BR/59/20/HH

Lansdowne House The Esplanade Bognor Regis PO21 1TR

New second floor balcony and inward opening French doors. (This application may affect the setting of The Steyne Conservation Area)

PROPOSED SECOND FLOOR PLAN

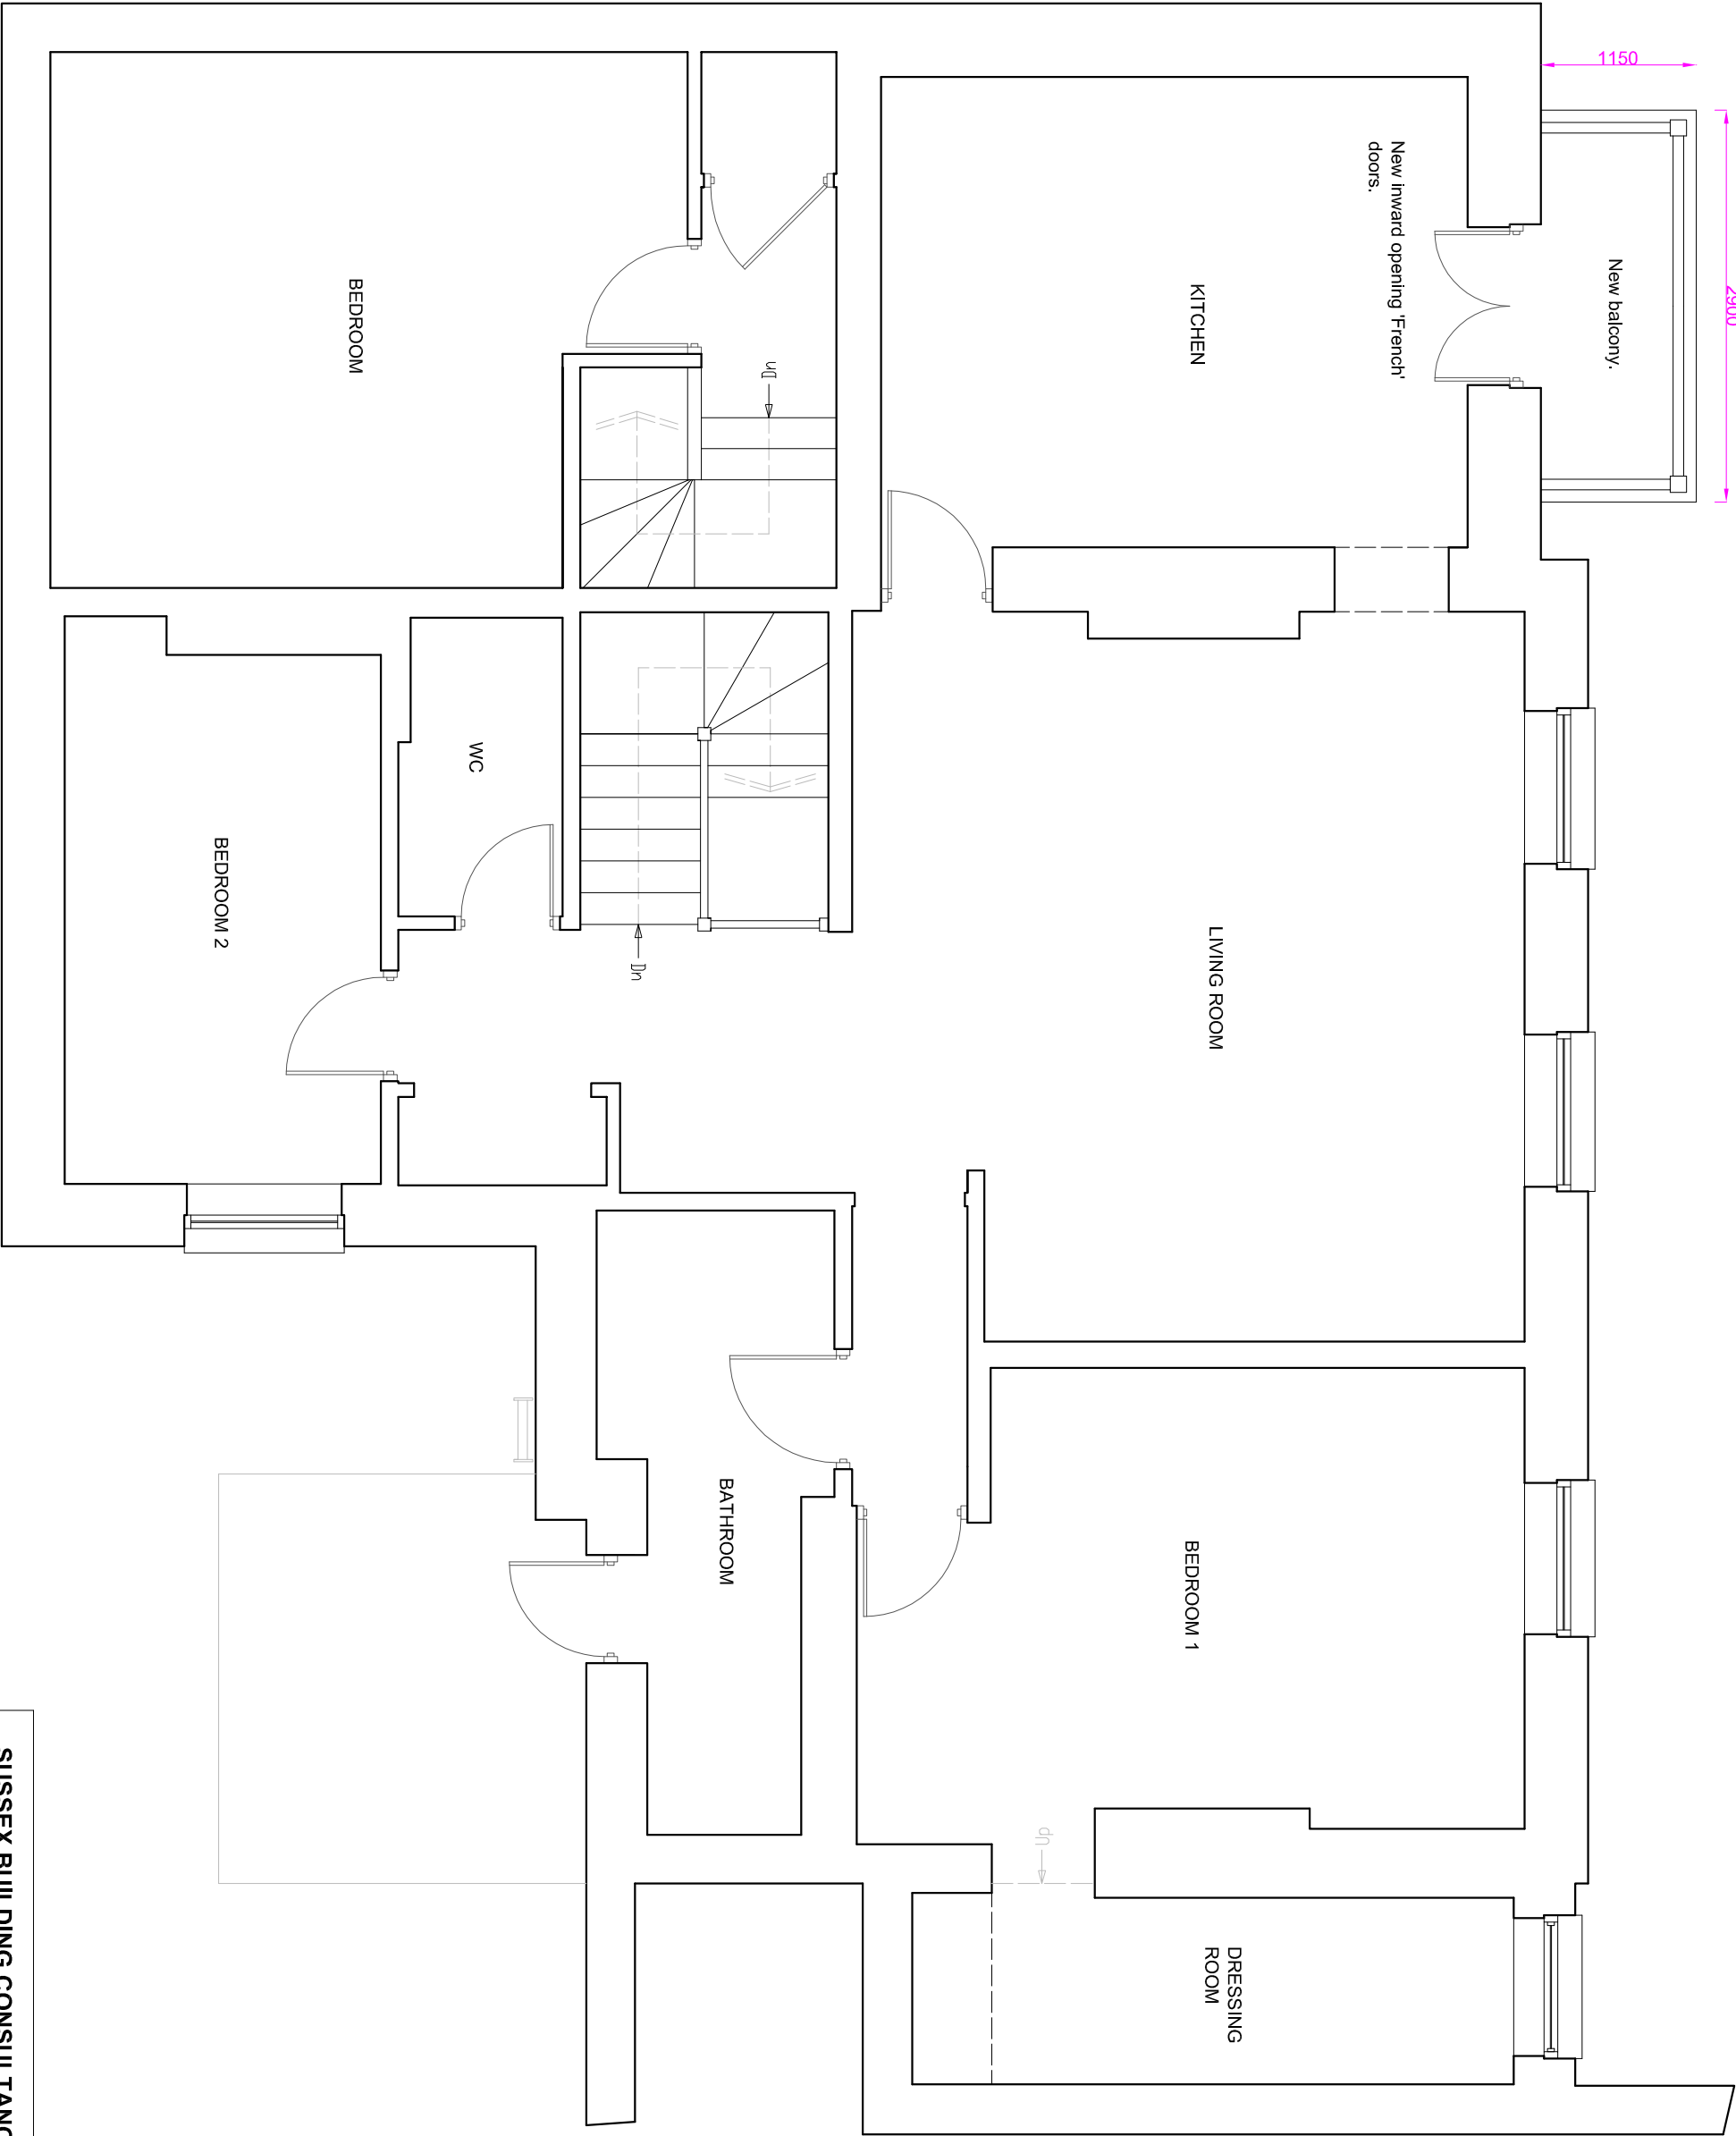
The application is for balcony and inward opening French doors to a second floor flat. The property fronts directly onto the esplanade and is three storeys high with commercial uses on the ground floor. It has a simple elevation which is rendered and painted white, with an entablature still present. Also, of note is the fenestration; the first-floor windows are larger than those on the second floor. The second-floor windows, whilst all appearing to be modern replacements have not affected/alterd the original openings themselves; i.e. dimensions and locations.

PROPOSED ELEVATIONS

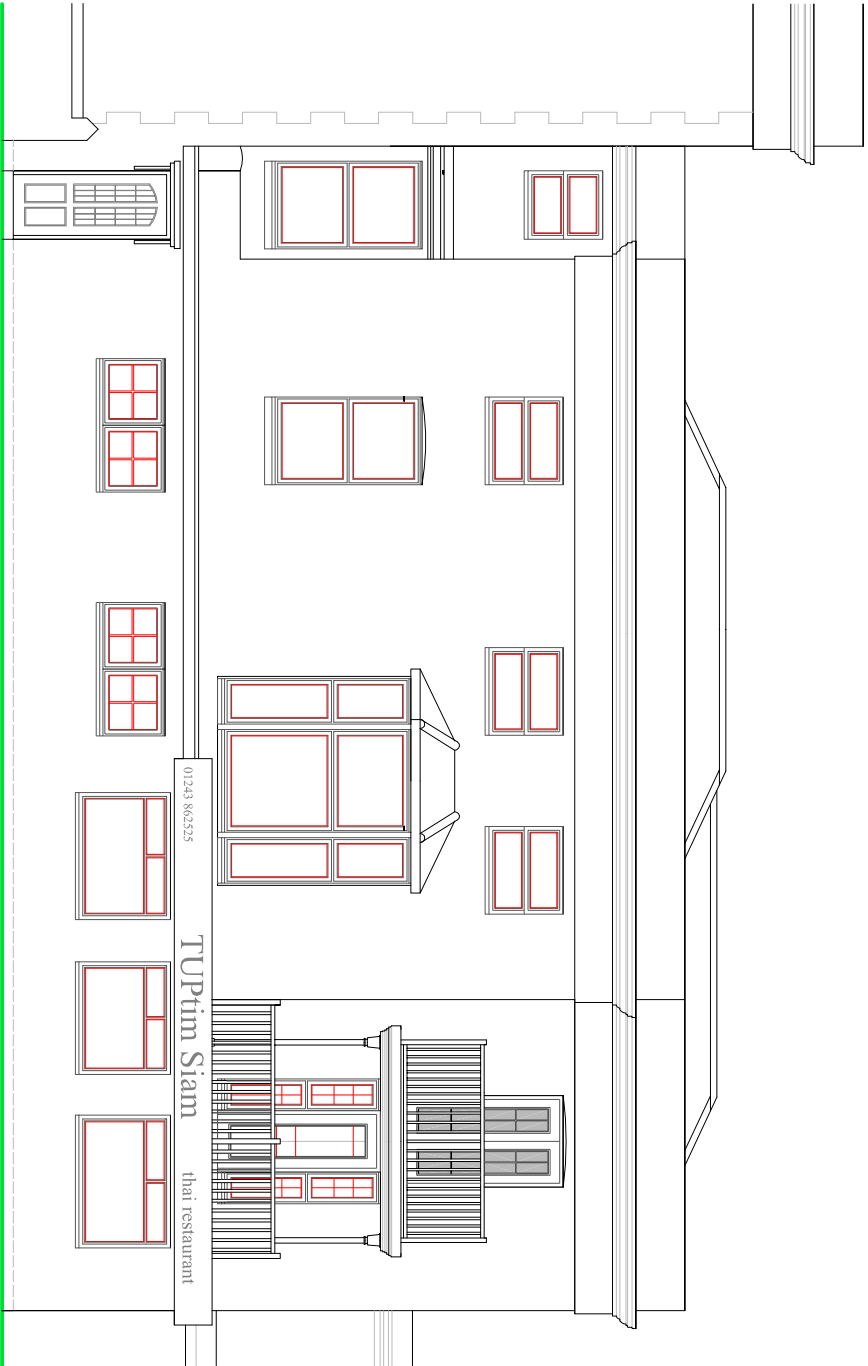
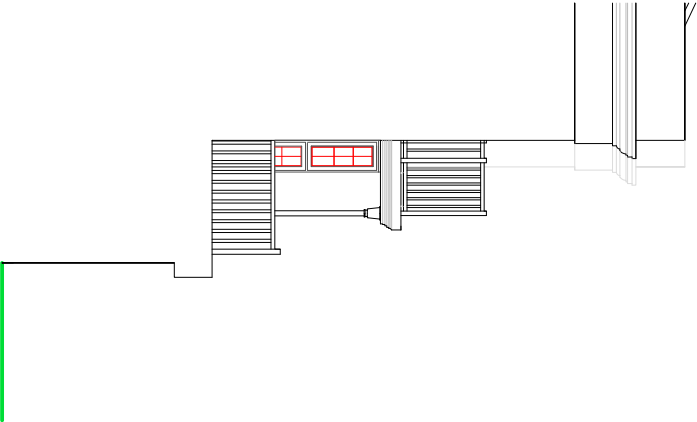
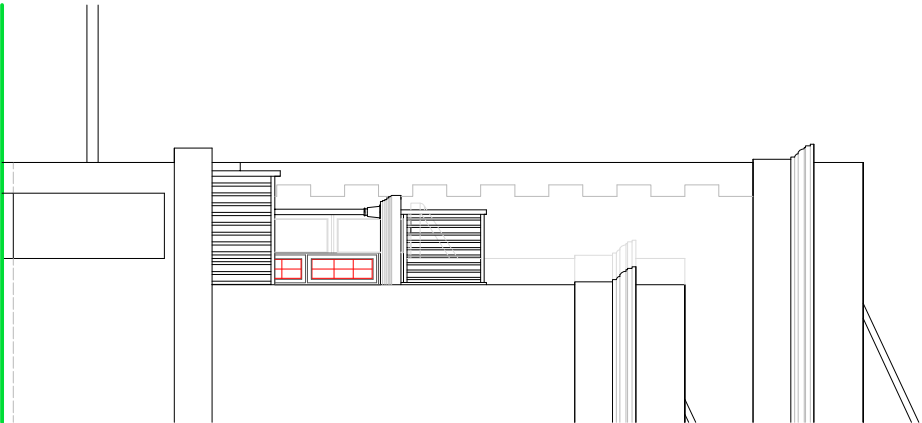
The design of windows/doors can have a significant impact on the character and appearance of a building, and therefore part of a conservation area. It is considered that the proposed balcony and associated French windows are problematic in that they directly affect the appearance of the upper section of the building. Introducing French Windows will result in the loss of the original openings and disturb the fenestration on this part of the building (i.e. the different spatial order mentioned above).

The proposal is such that the impact can be described as causing less than substantial harm in accordance with paragraph 196 of the NPPF (2018). As such, you will also need to consider the public benefits that the development may achieve as part of your assessment of the application, along with the contents of the Planning (Listed Buildings and Conservation Areas) Act 1990 (as amended).
